From: Sarah Burrow <Sarah.Burrow@arun.gov.uk>
Sent: 19 November 2019 15:22
To: Finlay Gardner <Finlay.Gardner@arun.gov.uk>
Cc: Planning.Responses <Planning.Responses@arun.gov.uk>
Subject: RE: Application BN/83/19/DOC

"Engineers Comments Regarding Surface Water Drainage Design"

FORMPAVE PERMABLE BLOCK PAVING CONSTRUCTION

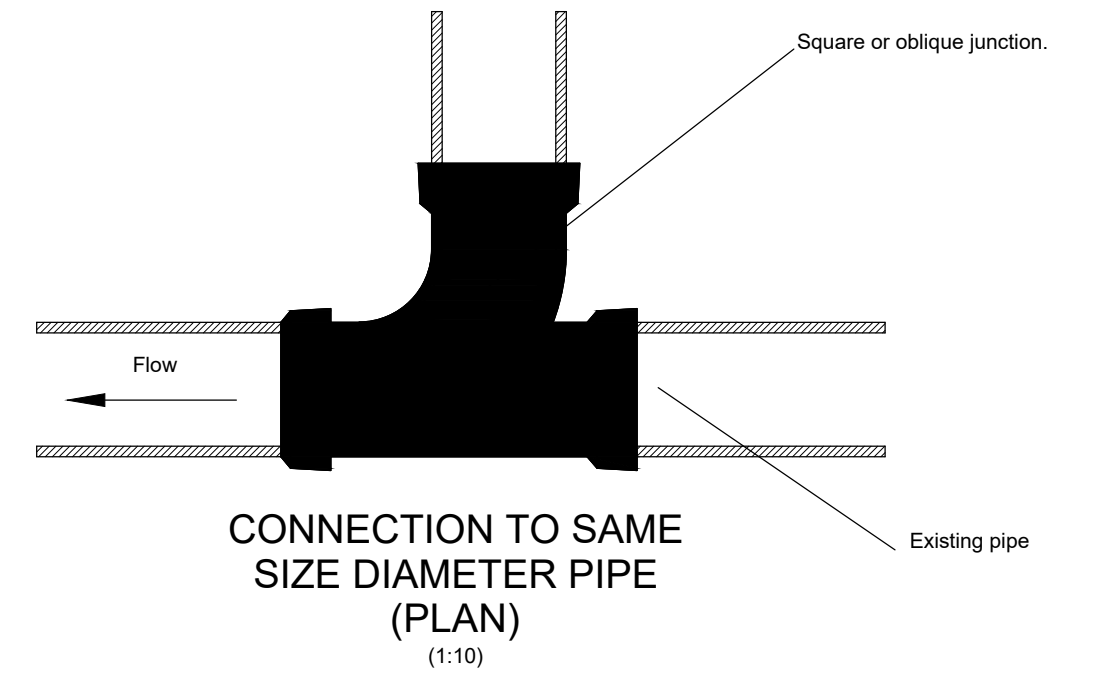
2. Please provide an impermeable areas plan or list so that the calculations may be checked.
3. No calculations have been provided for the permeable paving. Specify formation and surface levels on the layout plans. Specify type 3 stone for the sub base. If it is proposed that the permeable paving infiltrates to the ground beneath then infiltration testing in accordance with BRE365 will need to be completed at the appropriate depths and at an agreed time in the winter. If the permeable paving is to attenuate and discharge to the proposed geocellular soakaways then this should be shown in the design drawings and allowed for within the calculations. Levels, etc may prevent this option.

1. The design has been adjusted to suit the testing and was re-submitted. Calculations attached again indicating shallower soakaways.
2. Attached
3. The porous paved area will self-drain similar to any landscaped areas albeit with the addition of extra volume in the sub base. Calculations for this type of porous paving do not reflect this as flows are directed to a specific node on the network as opposed to the whole areas. The testing revealed similar strata throughout all depths so infiltration rates will be similar. If this is unacceptable then we will connect into a soakaway and increase the size to suit. Levels now taken and added the porous paving. Please confirm why Type 3 is preferred over a 5/20mm stone. We have retained the 5/20 stone otherwise we will lose any warranty with the manufacturer.

450mmØ POLYPIPE BASIC SILT TRAP DETAIL

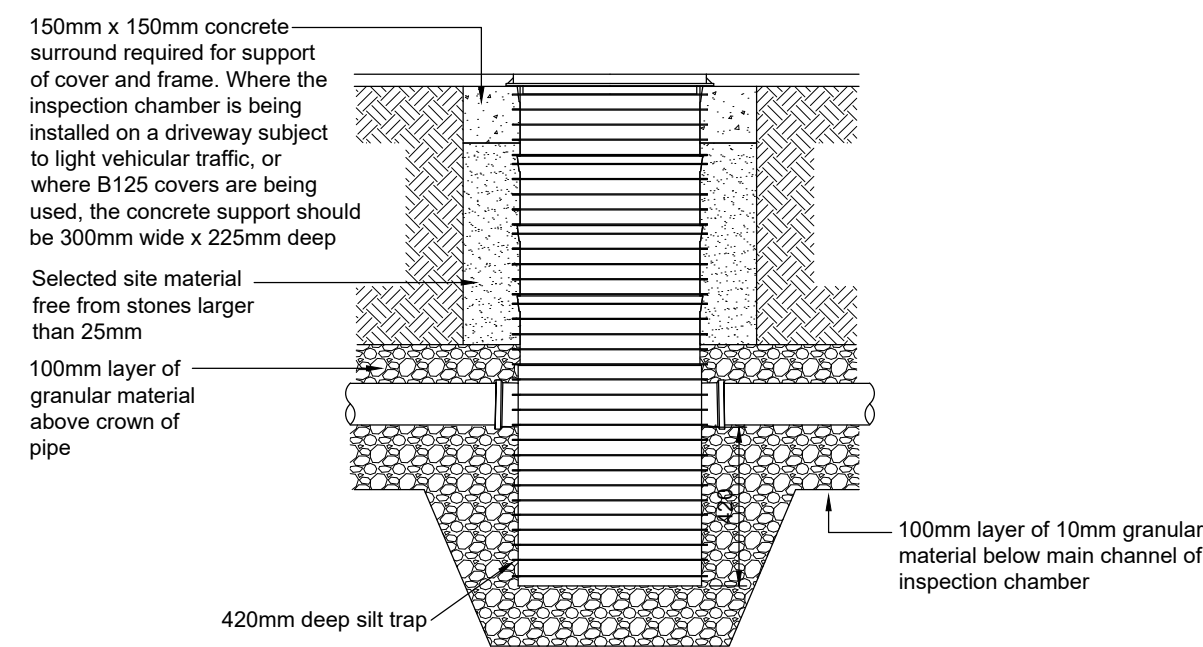
9. The silt trap construction detail sump depth does not correspond to that shown on the drainage layouts.
10. The percolation test hole dimensions do not comply with the requirements of BRE365 i.e. should be 0.3m to 1m wide x 1m to 3m long. Would welcome your comments in this respect.

8. Ratio-R adjusted to 0.35
9. Sump depth adjusted on drainage layout
10. Agreed and going forward we will bear this in mind as this was not an issue on previous applications. The calculations stay the same so we would like to keep the tests as they are.

SOAKAWAY USING SDS GEOLIGHT 400 GEOMODULAR UNITS

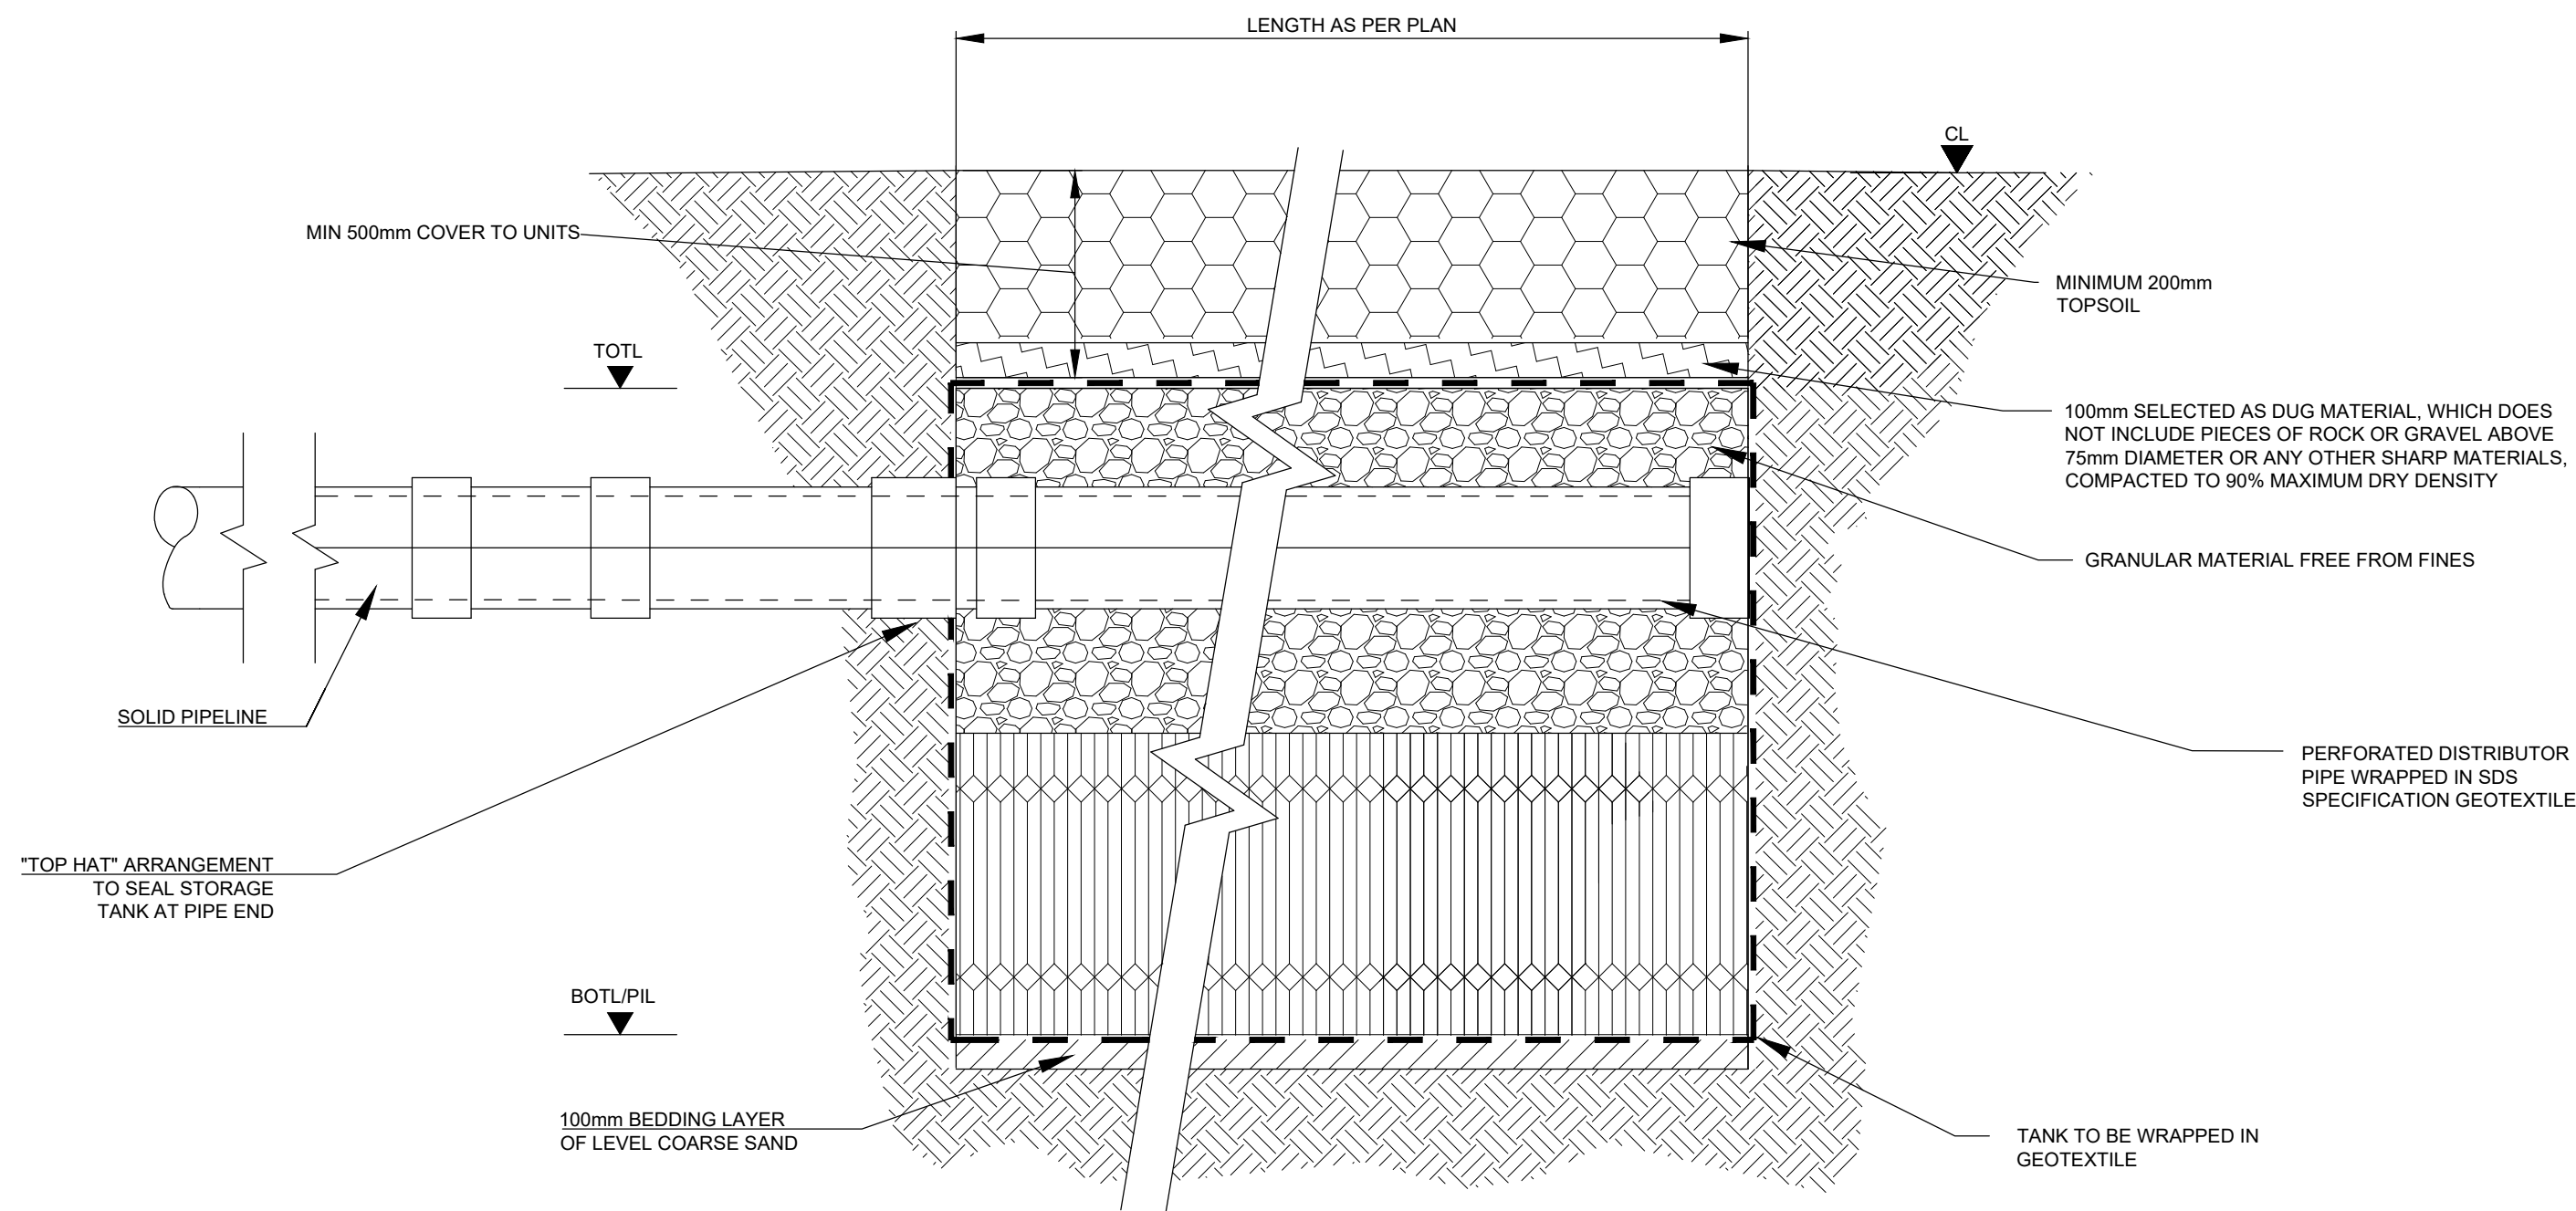
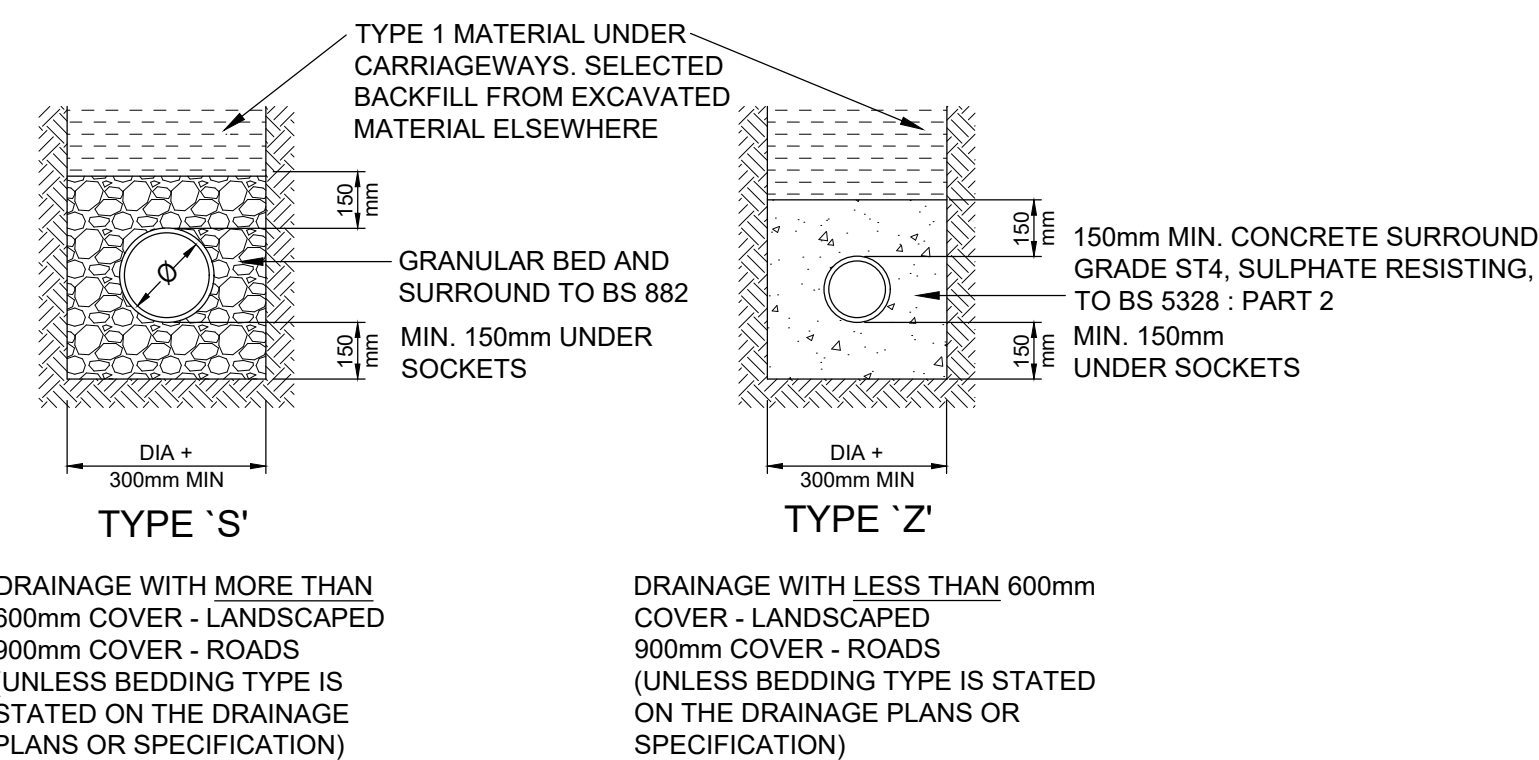
5. Please provide the results (raw data) of your infiltration testing so that the infiltration calculations can be checked.
6. Soakaway detail needs to clearly show a geotextile permeable membrane between the crates and the granular material in order to prevent granular material entering the crates. Please also make it clear that all geotextile wrapping is permeable. In addition the site specific cover, invert levels and crate depths should be shown on the construction detail drawing.

7. Please confirm and note on your details if the perforated pipes that are proposed will be fully perforated or half.
8. Within the calculations the Ratio-R needs to be adjusted to approximately 0.35 as is the norm for this area.

6. Noted and adjusted. There are two soakaways so levels not added to detail but references made clearer
7. Perforations facing down and note adjusted to suit

DRAWING TITLE				
SURFACE WATER DRAINAGE LAYOUT 'COPEFIELD LODGE'				
DRAWN	ENGINEER	CHECKED	APPROVED	
CS	C SLADE	CS	SB	
DATE	SCALE @ A1			
SEPT 2019	1:100			
JOB No.	STATUS	DRAWING No.	REV.	
C1255	P	101	P-

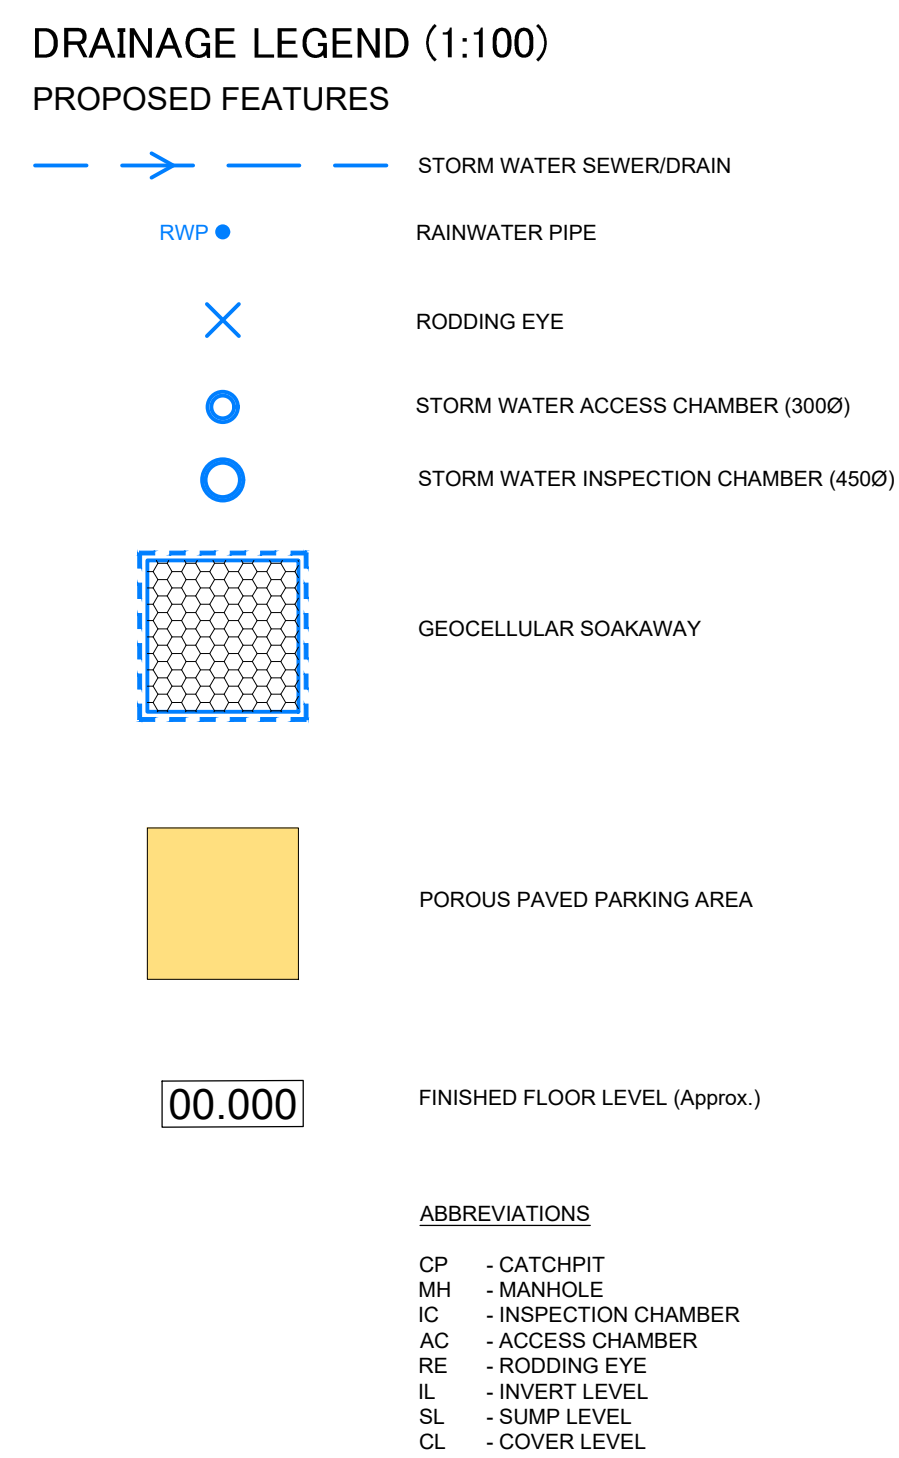
1. The proposed soakaways are at a greater depth than the infiltration testing depth. The applicant has two options; redesign the soakaways to a shallower depth with a greater surface area, OR, recomplete infiltration testing in accordance with BRE365 to a greater depth at an agreed time in the winter. However, the calcs show a different story in terms of proposed base levels – please clarify.
